Current Zoning: N1-A (Neighborhood 1-A)
Proposed Zoning: N2-B(CD) (Neighborhood 2-B, Conditional)

Approximately 7.17 acres located on the south side of York Road and west side of Youngblood Road.

The petition proposes to allow an age restricted multifamily stacked development with up to 160 dwelling units on a vacant parcel in the Steele Creek community.

JOB NO. 62387
 SHEET NO. RZ-1

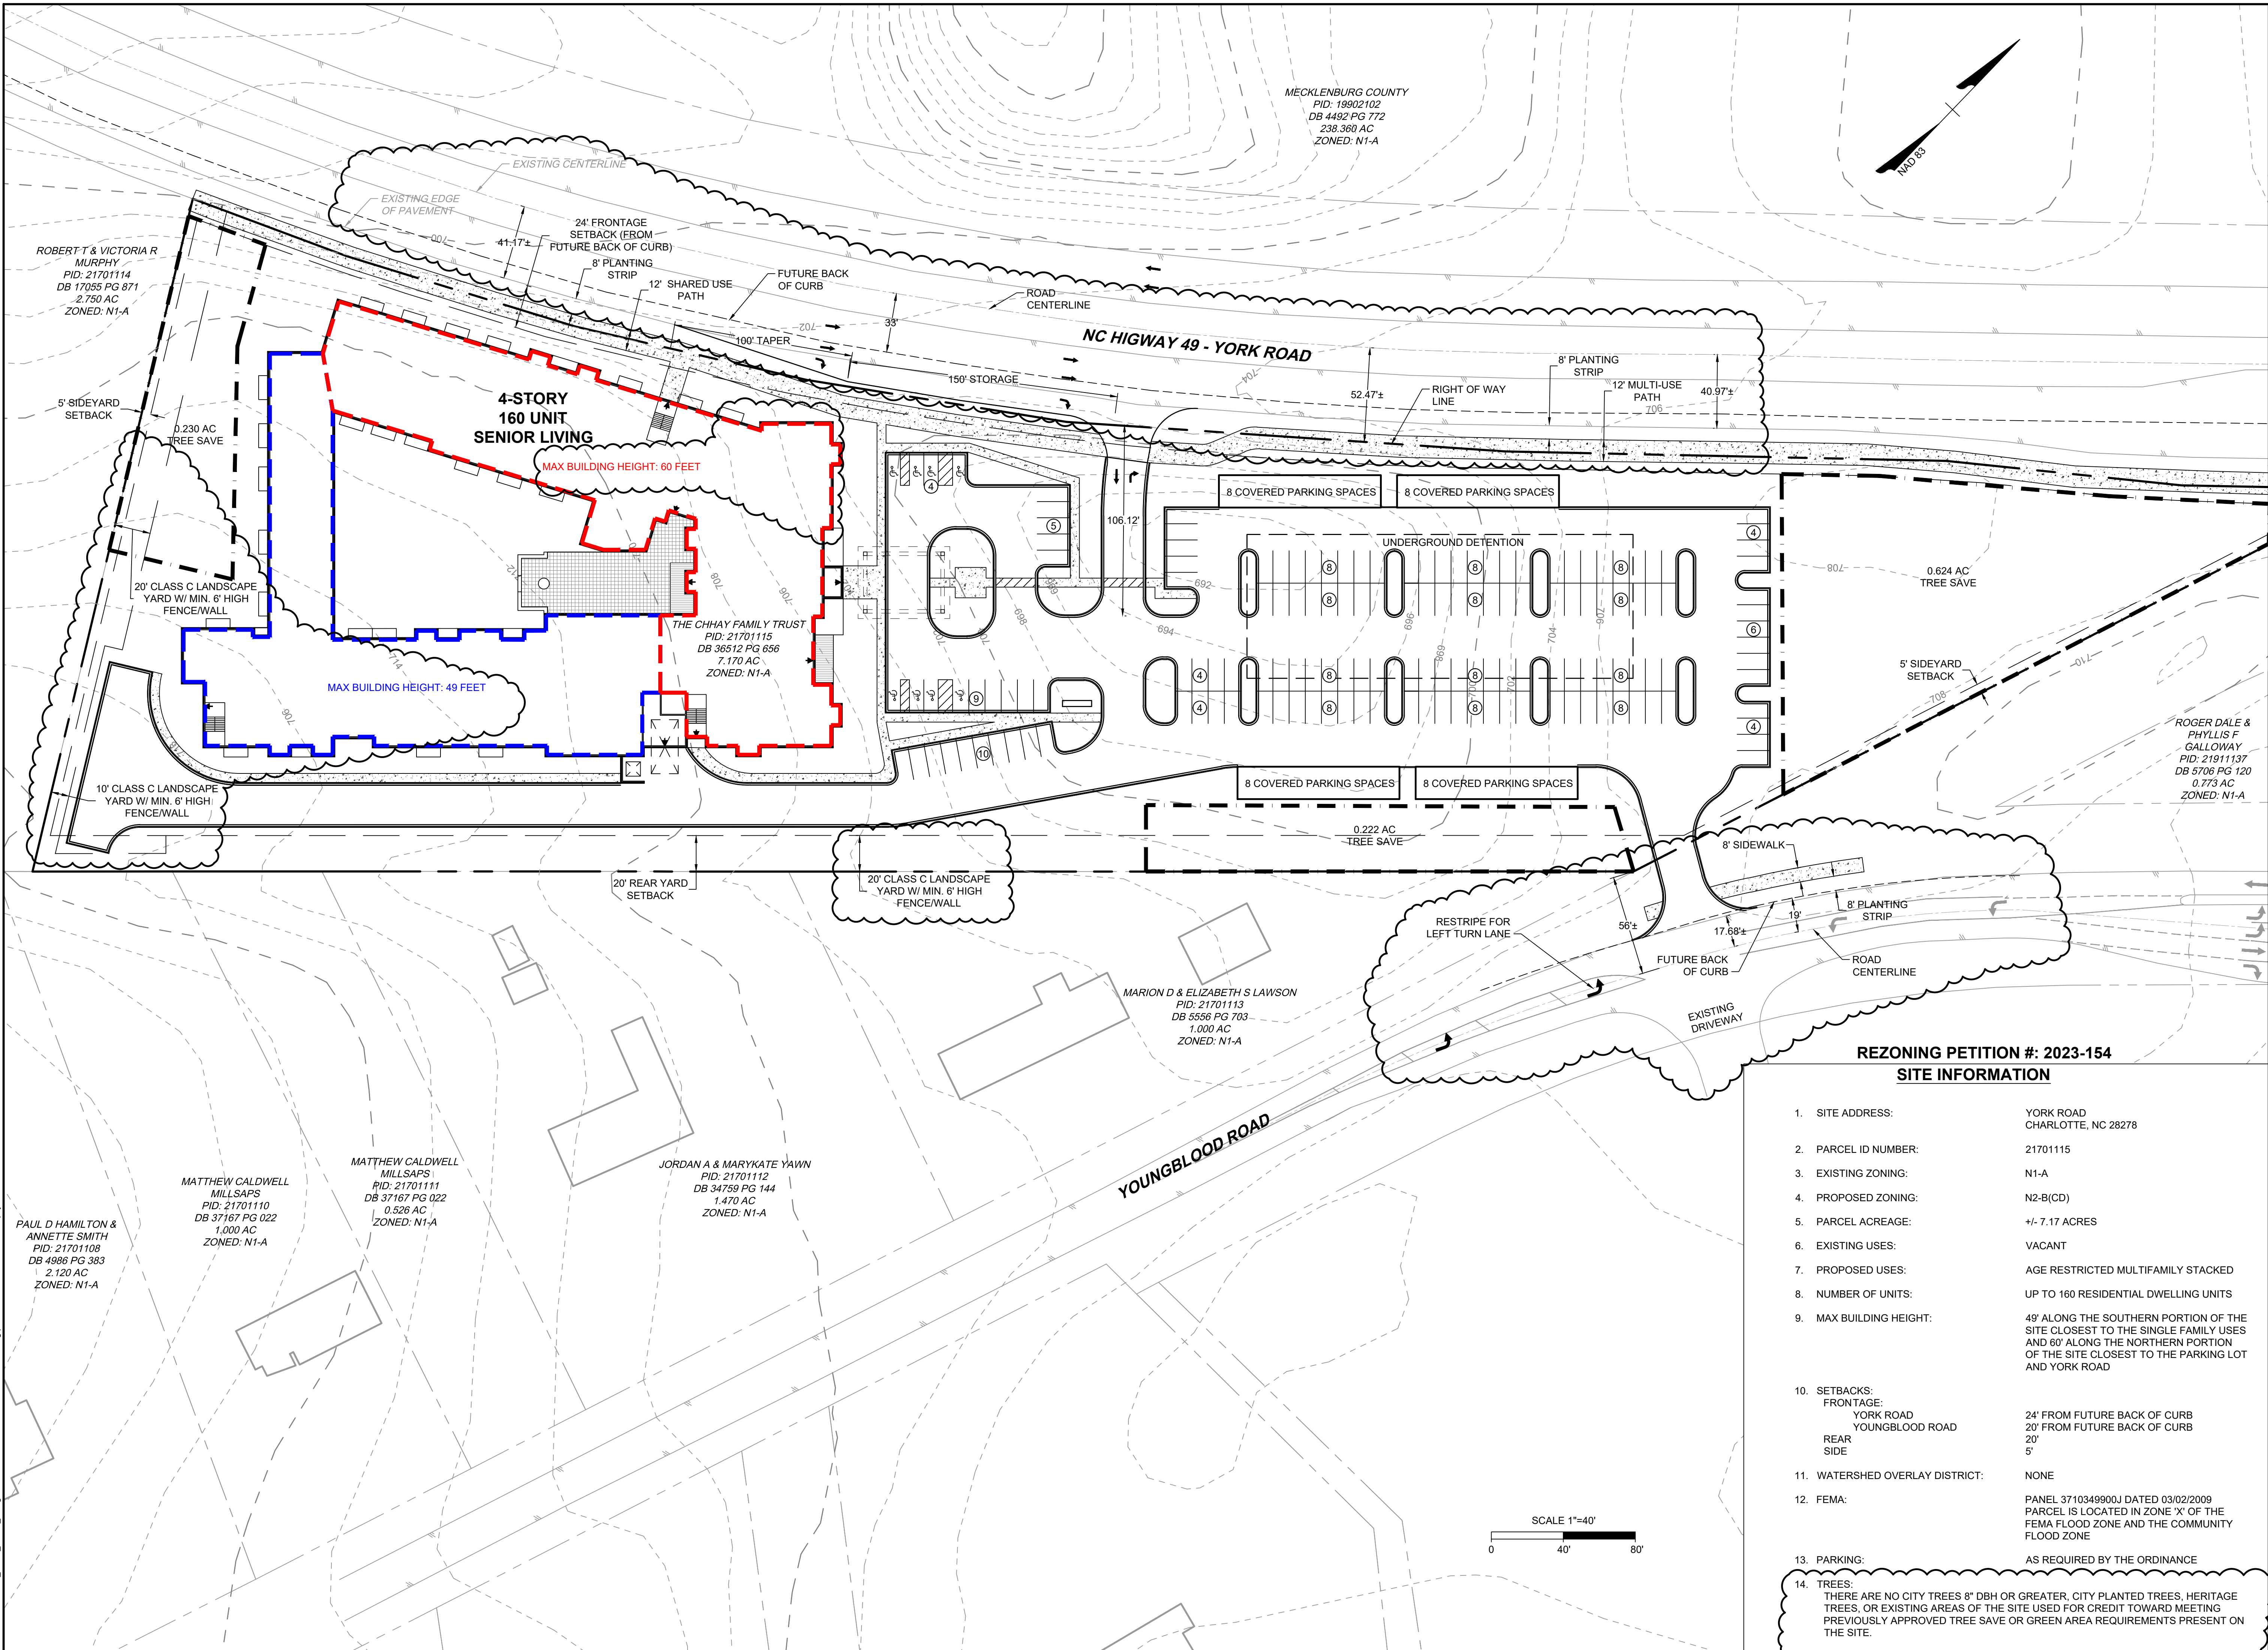
2. Provide a tree survey showing all city trees 8" DBH or greater and all planted city trees, all existing heritage trees on site, and any existing areas of the site used for credit toward meeting previously approved tree save or green area requirements. **OUTSTANDING**
3. Verify that tree save areas are contiguous. **OUTSTANDING**

- ~~7. Revise site plan and conditional note(s) to commit to restriping a left turn lane into the site off of Youngblood Road.~~ ADDRESSED
8. Revise site plan and conditional note(s) to construct 8-foot planting strips and 12-foot multi-use paths on York Road and Youngblood Road. The site plan shall label and dimension both items from the back of curb and gutter or edge of pavement. Add conditional note stating the entire facility must be outside of the right of way and within a public access easement. Add conditional note committing to construction and maintenance of the 12-foot multi-use paths on York Road and Youngblood Road. Revise site plan to show all sidewalk outside of the NCDOT right-of-way and inside a public access easement. **OUTSTANDING**
